Our Ref: DOC21/291828
Your Ref: SSD 10398

RE: Hanson Tweed Sand Plant Expansion, Cudgen Tweed LGA, (SSD 10398)

Enclosure: Attachment 1: Detailed BCD Comments – Hanson Tweed Sand Plant Expansion at Cudgen (SSD 10398)

SECTION C
1:150 AT A1

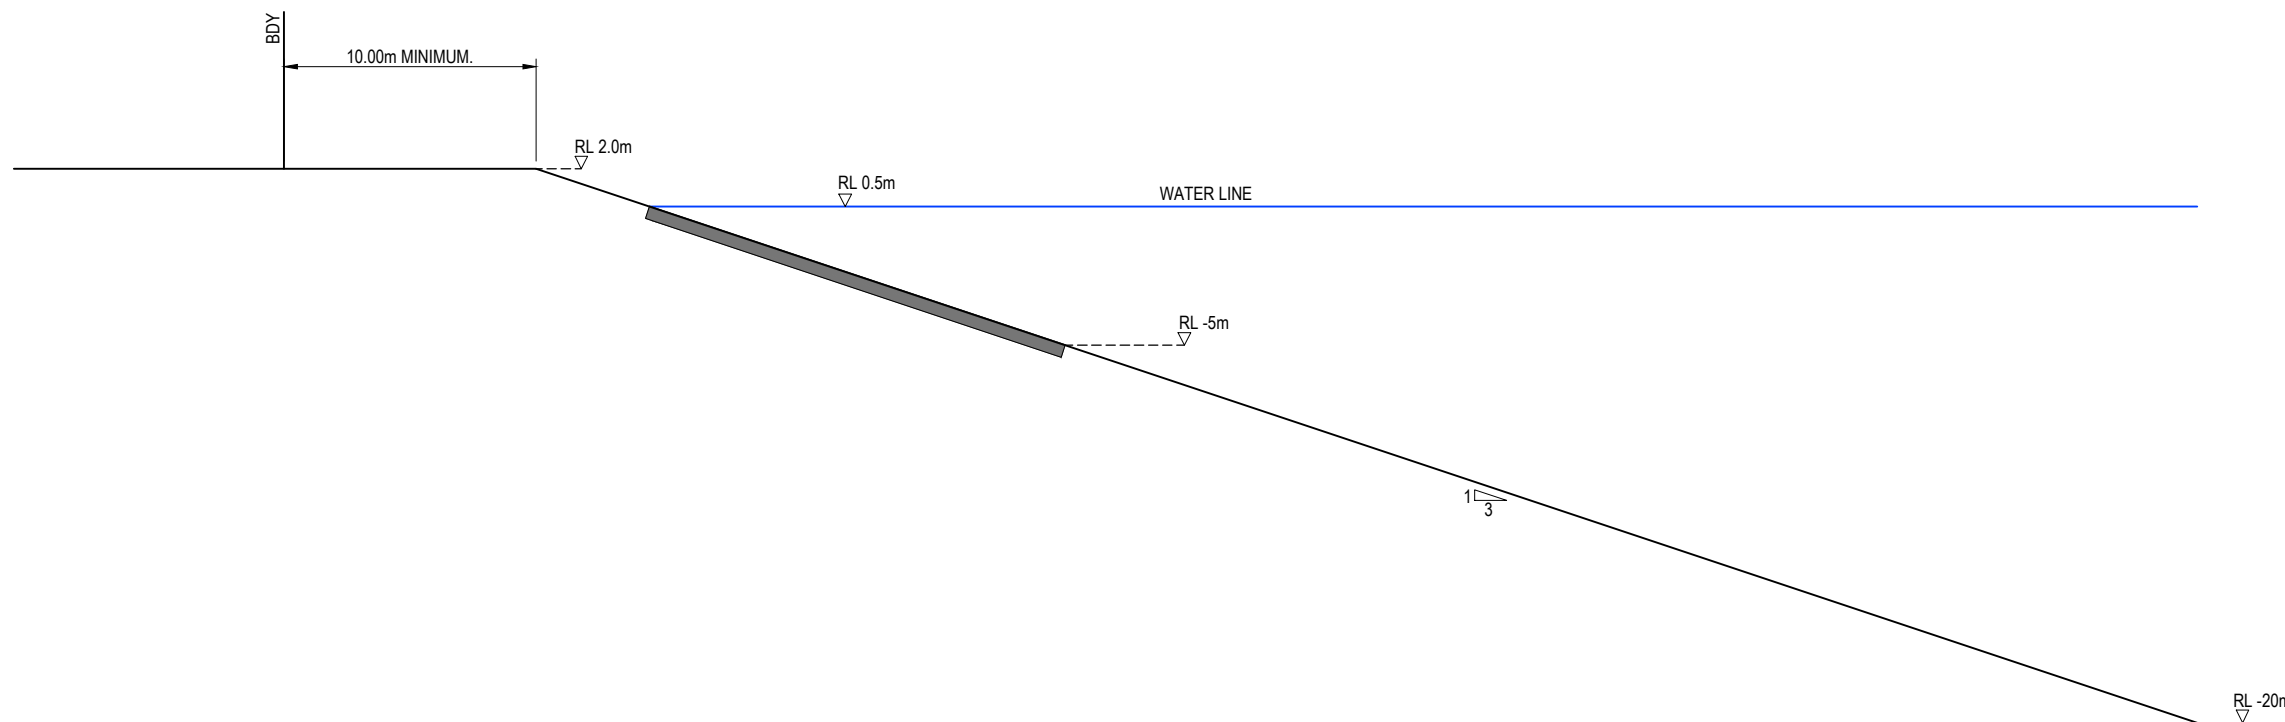
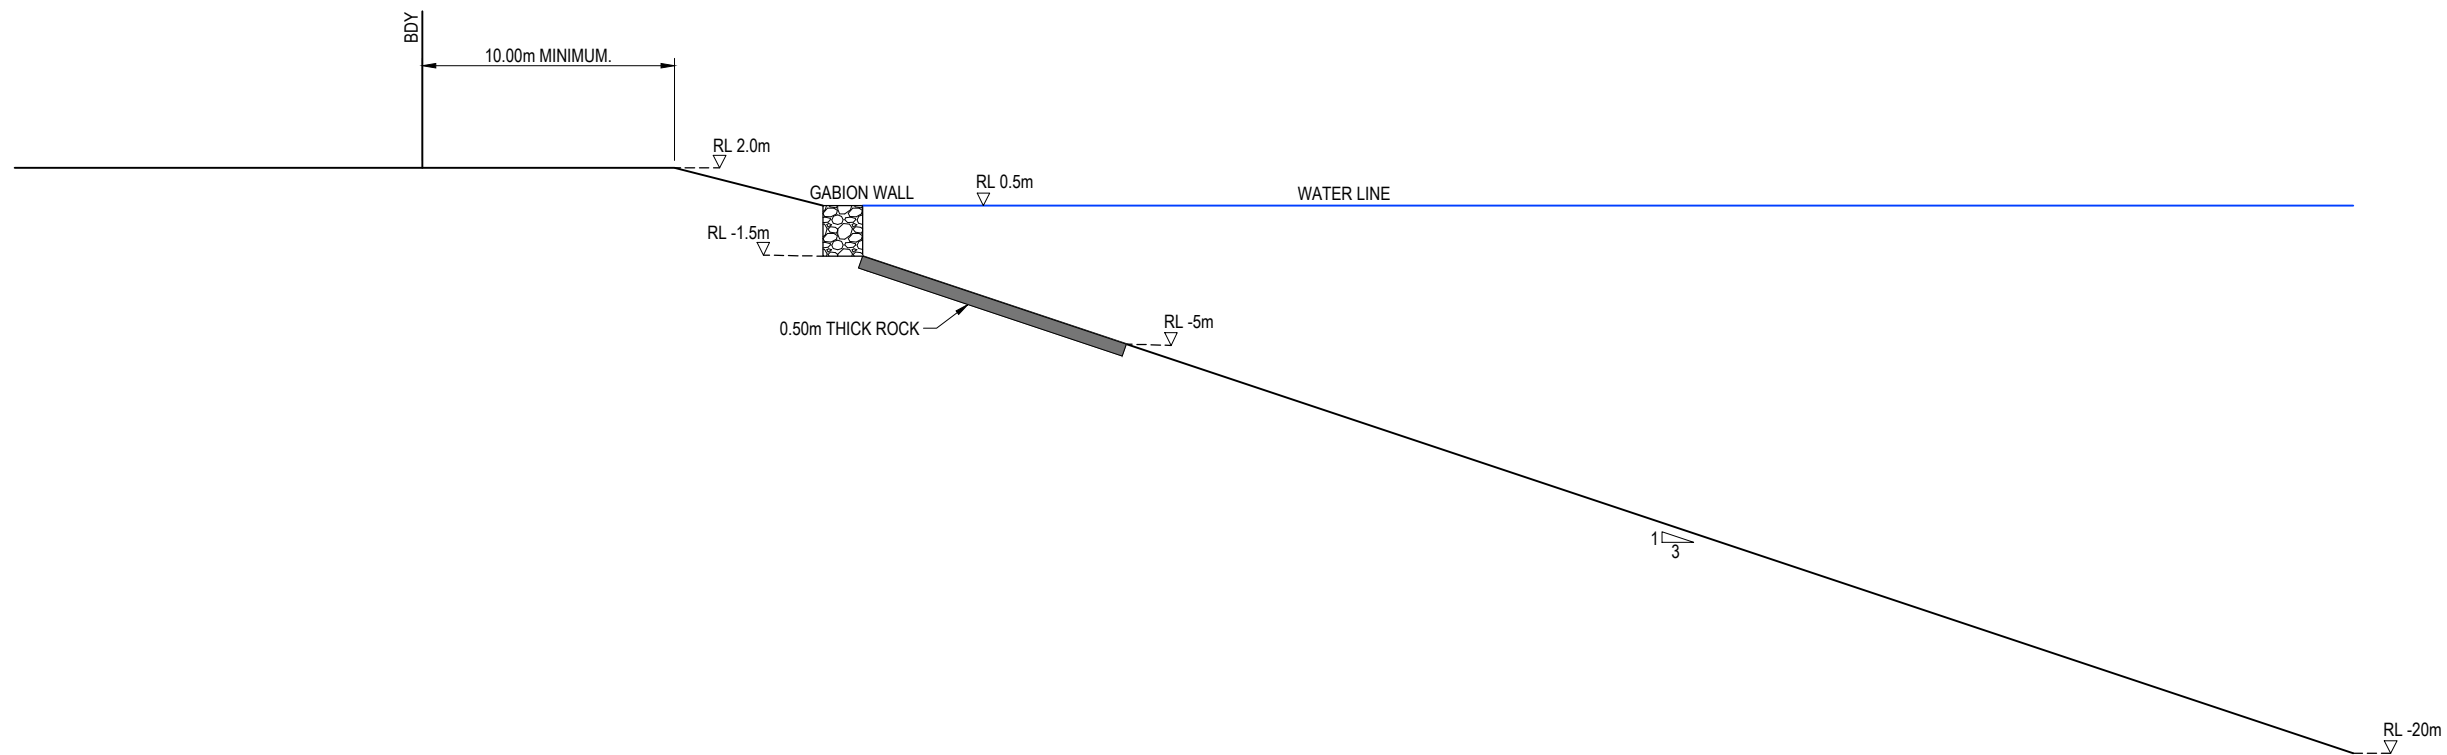
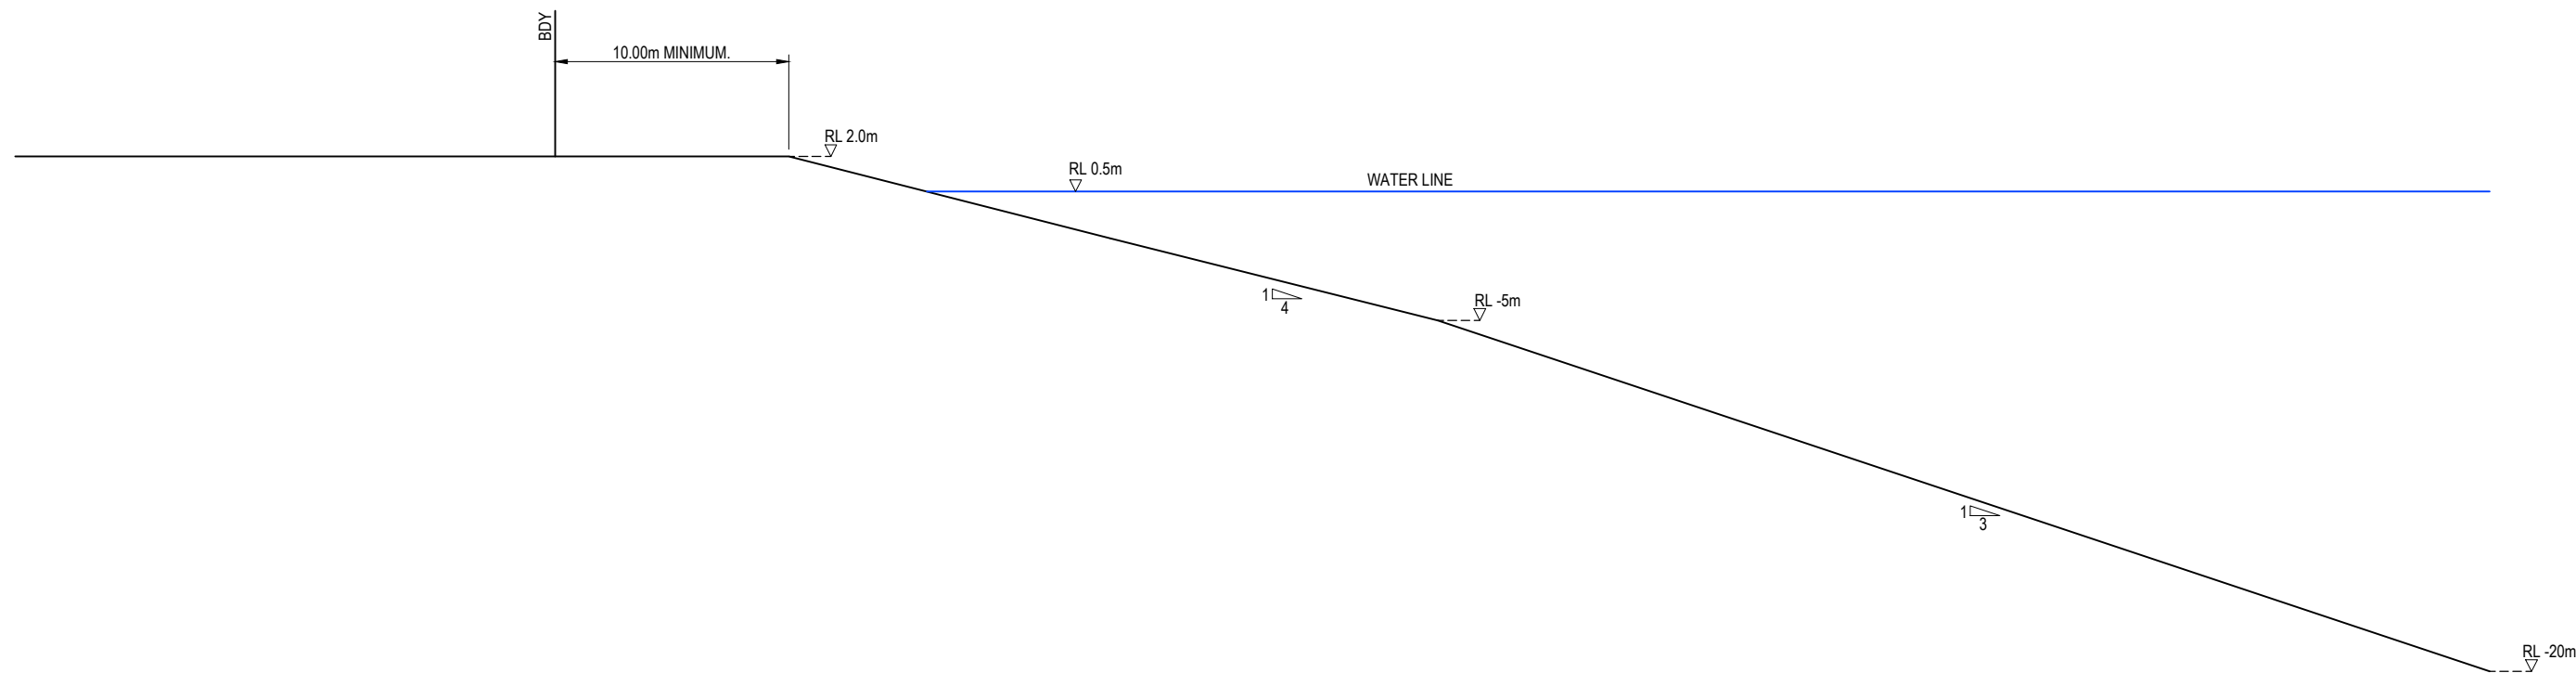
The proposed minimum 10m width of vegetation to fringe the future lakes does not appear to include any provision for vehicular access, bike/walking trails and open space as well as sufficient area to plant a riparian zone, particularly given advice in the EIS about the potential for future inundation due to sea level rise. Although there may be opportunities to create open space areas, riparian rehabilitation areas should be entirely vegetated and not be identified for open space. Such open space recreational areas should be additional to that required for rehabilitation.

The BAM 2020 prescribes riparian buffer distances of 50m for estuarine areas, 50m for important wetland and 20m for other wetlands. While none of these directly apply in this instance we recommend as a minimum that the final landform include 20m – 50m wide fully vegetated riparian areas. It should also include a minimum 10m wide wetland revegetated area with appropriate slope to enable effective restoration to occur and for areas to be maintained in the future.

7. If the consent authority decides to approve this development, the riparian rehabilitation should provide as a minimum, 20m – 50m wide fully vegetated riparian areas. It should also include a minimum 10m wide wetland revegetated area with appropriate slope to enable effective restoration to occur and for areas to be maintained in the future.
